From: Joe Gilbert
Sent: Thursday, December 12, 2013 2:35 PM
To: Cruse & Associates (cruseandassoc@kvalley.com)
Cc: Jeff Watson
Subject: Smith BLA unofficial comments
Attachments: 1778_001.pdf

Hello again, I had John stop by and give me the run down, after identifying the well heads (attached) I ran into a small problem, it appears the well head for Johns main house is 50' from proposed prop line, but the shared well for the two other rentals is not. Not that it has to be because it is a shared well.... But it does need to remain on the parcel for which it serves the two other homes.... So that line will need to be changed and the well heads and distances will need to be on the next submittal, other than that it looks good.

PROPOSED

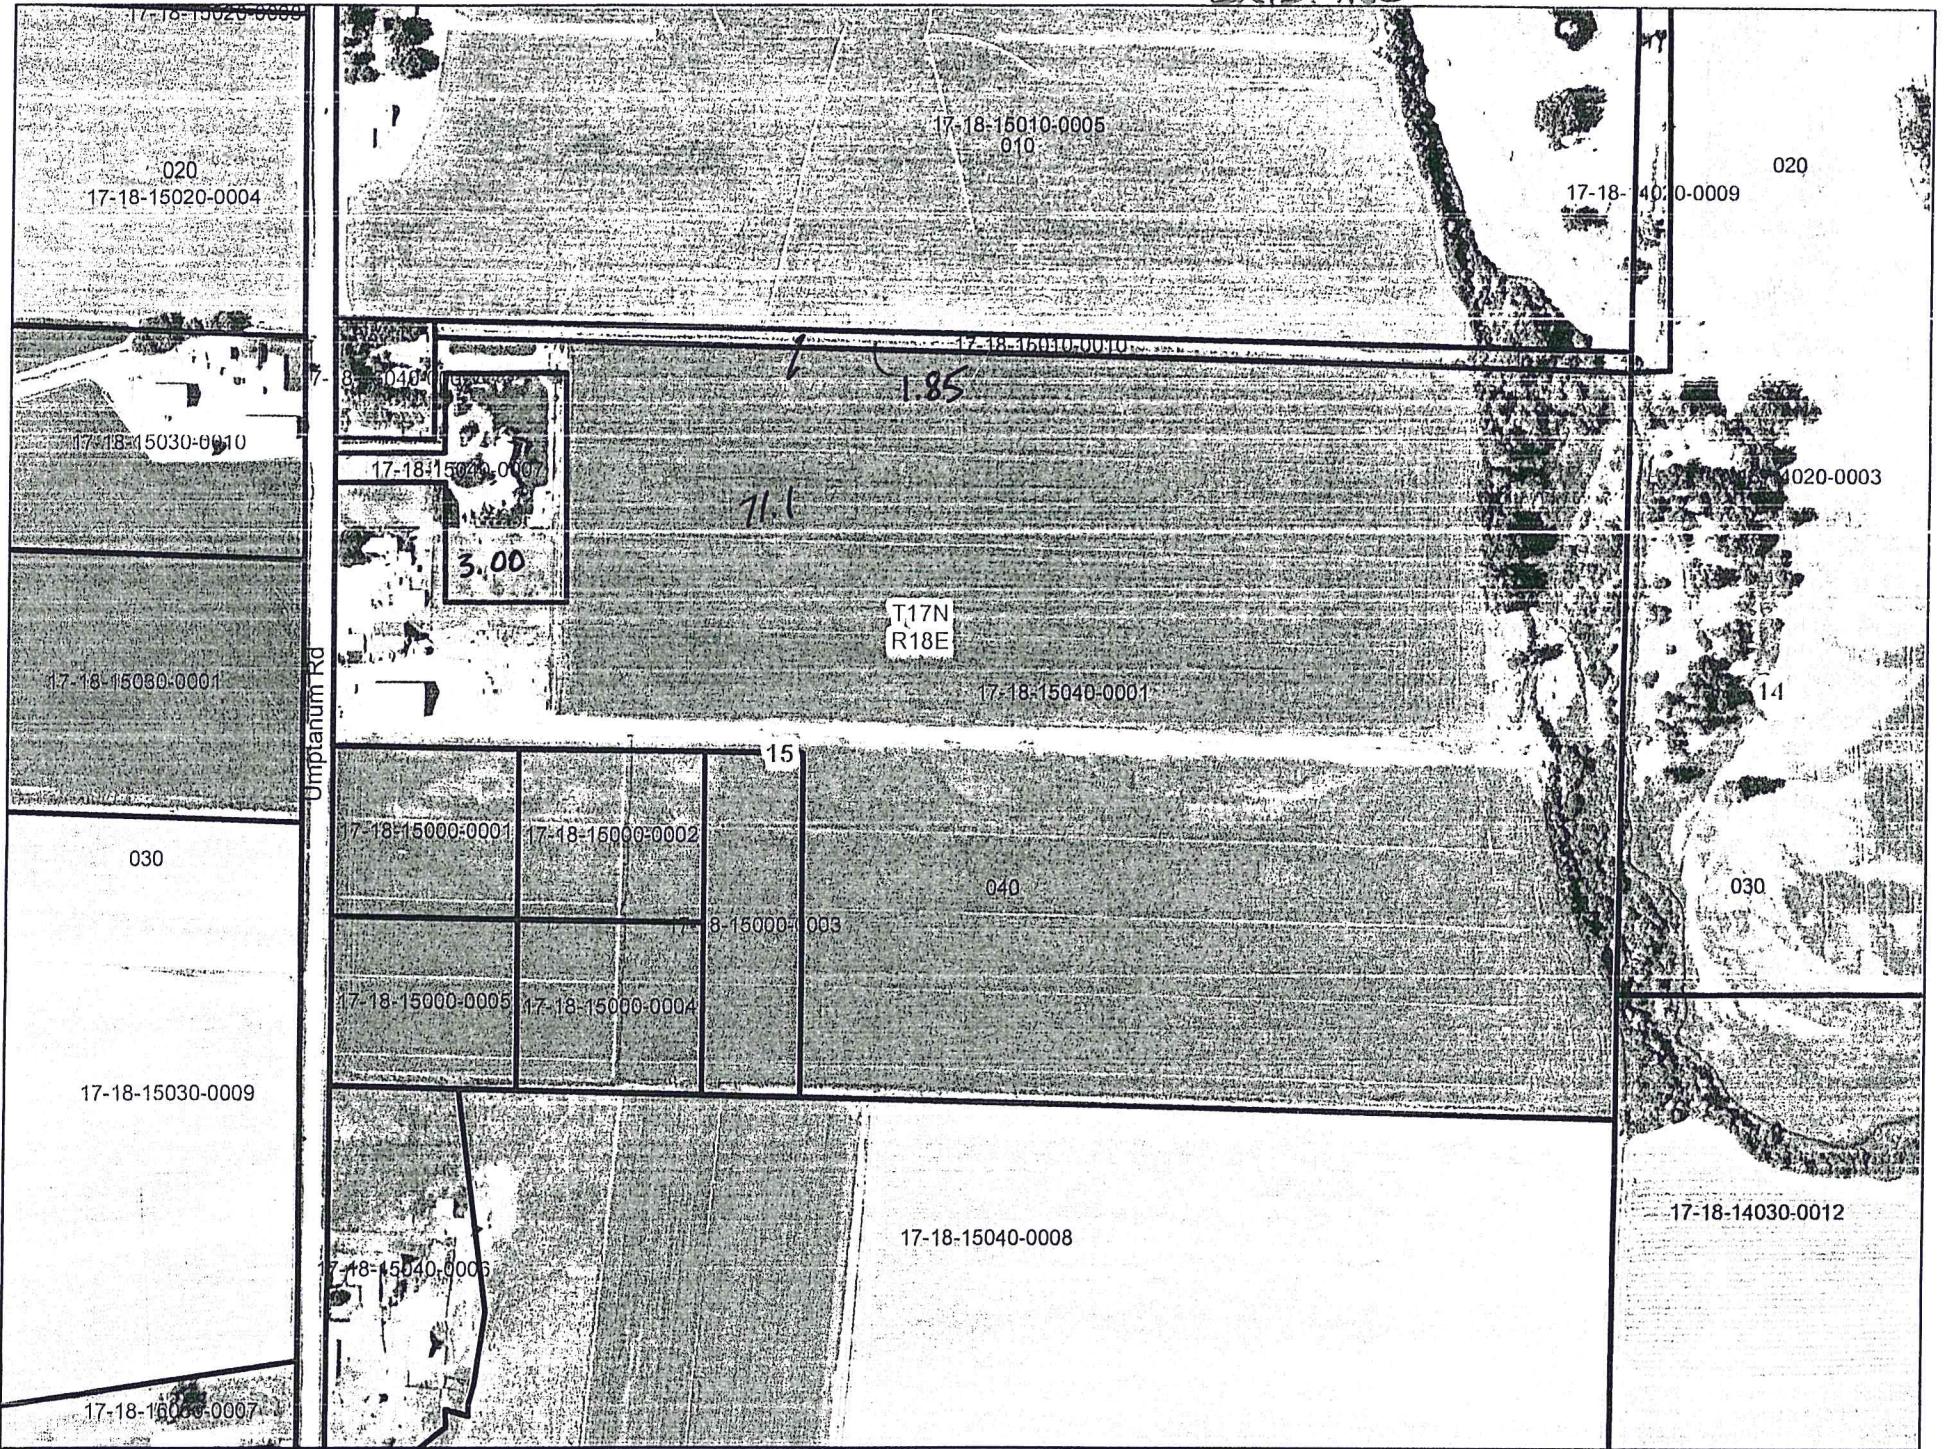
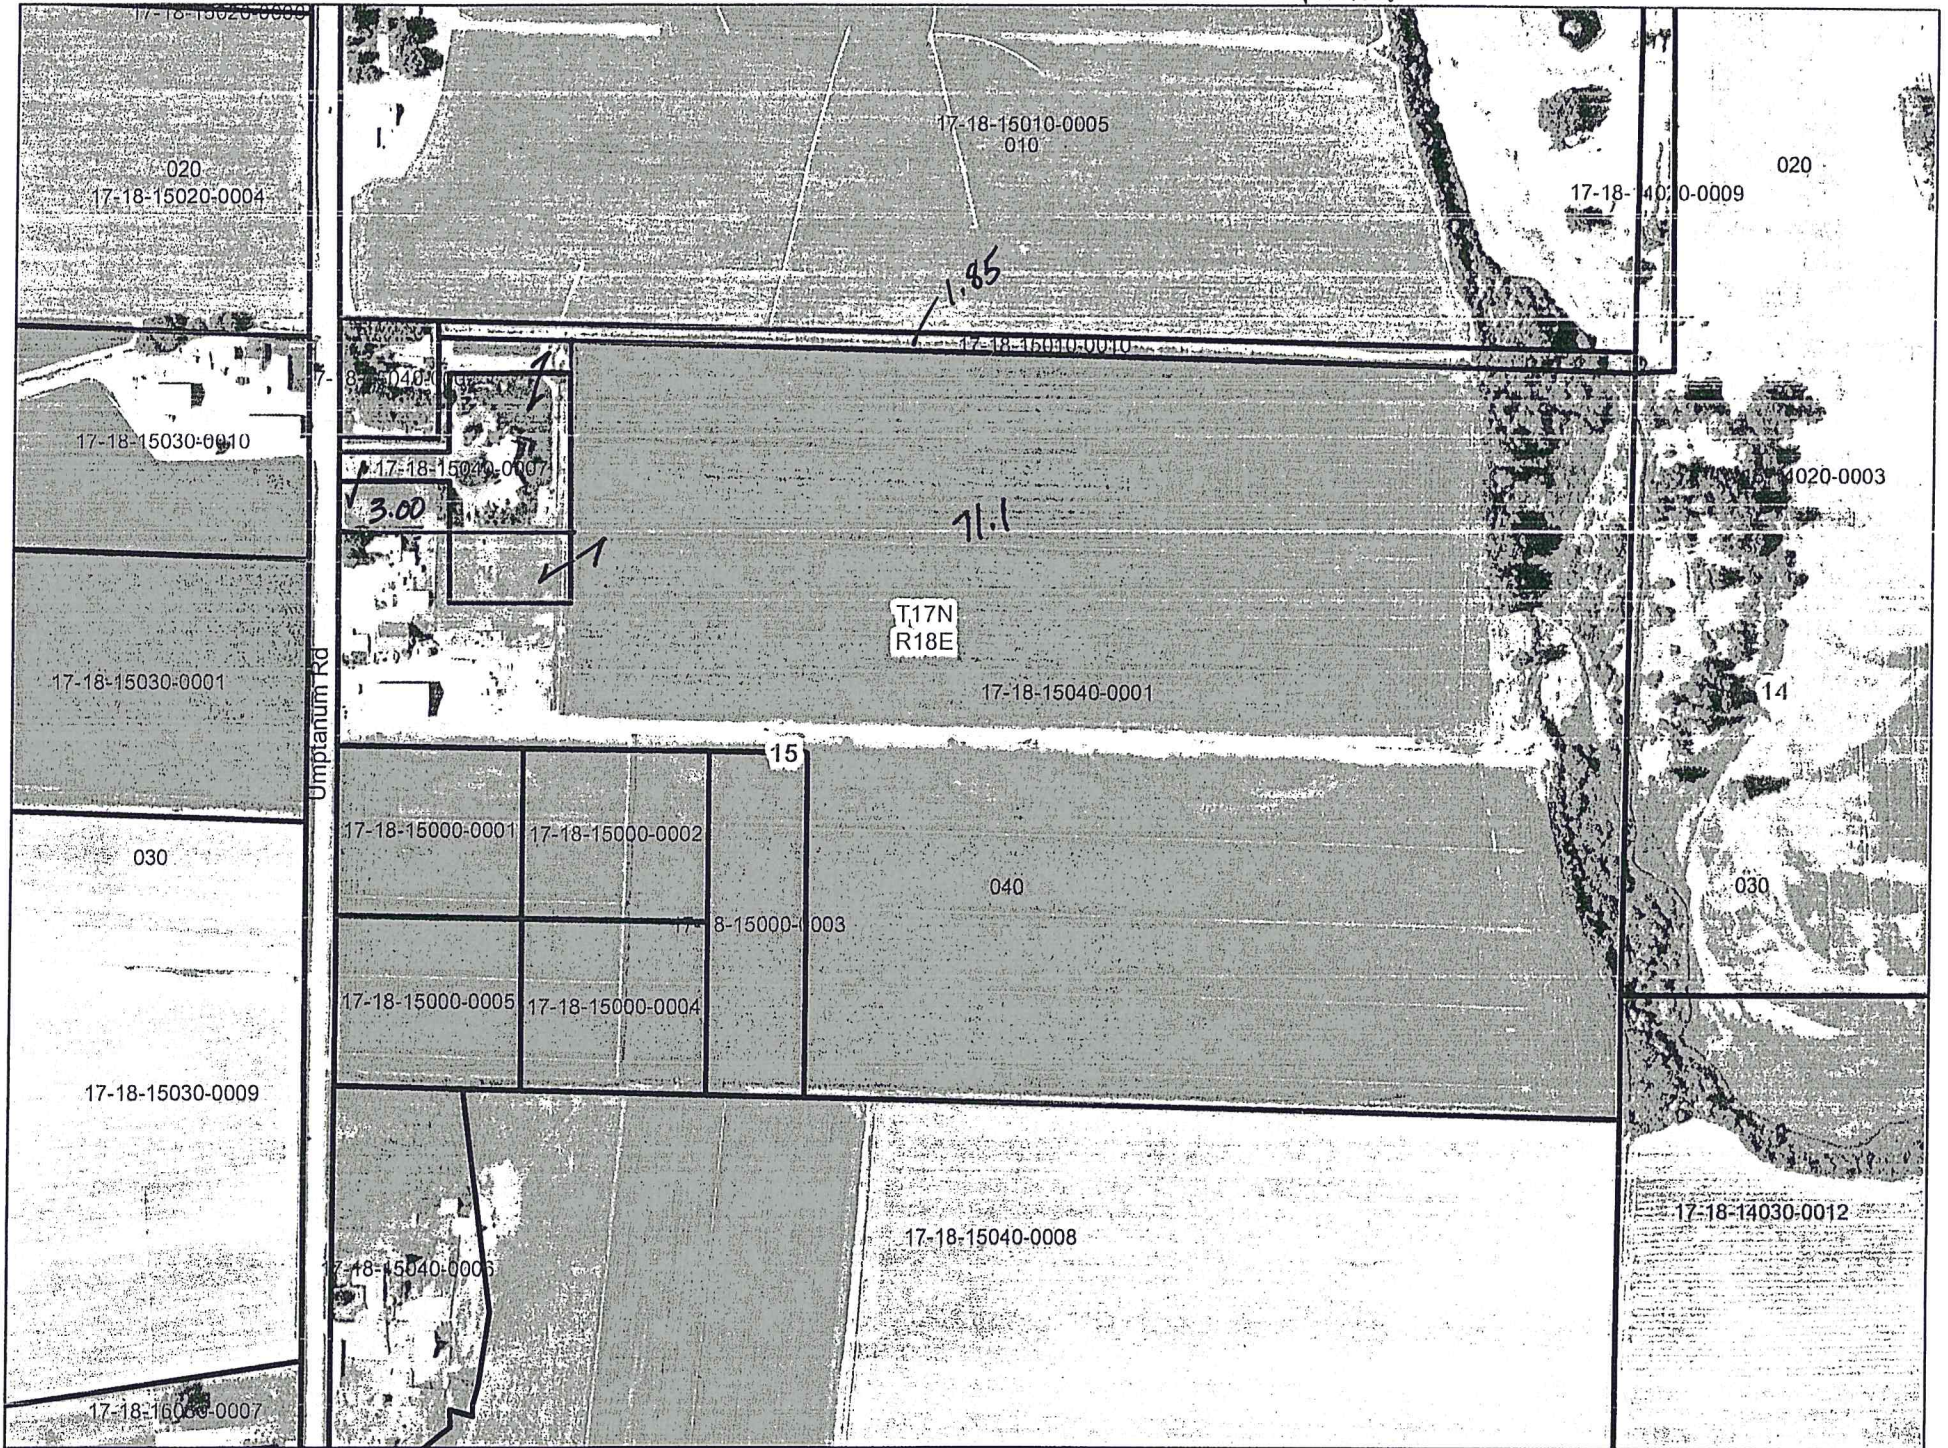
It will just prevent having to deal with easements, agreements etc.... I hope this makes sense let me know if you have any questions, once this is resubmitted as described above I can move it along (send final approval comments to Jeff)... thanks.
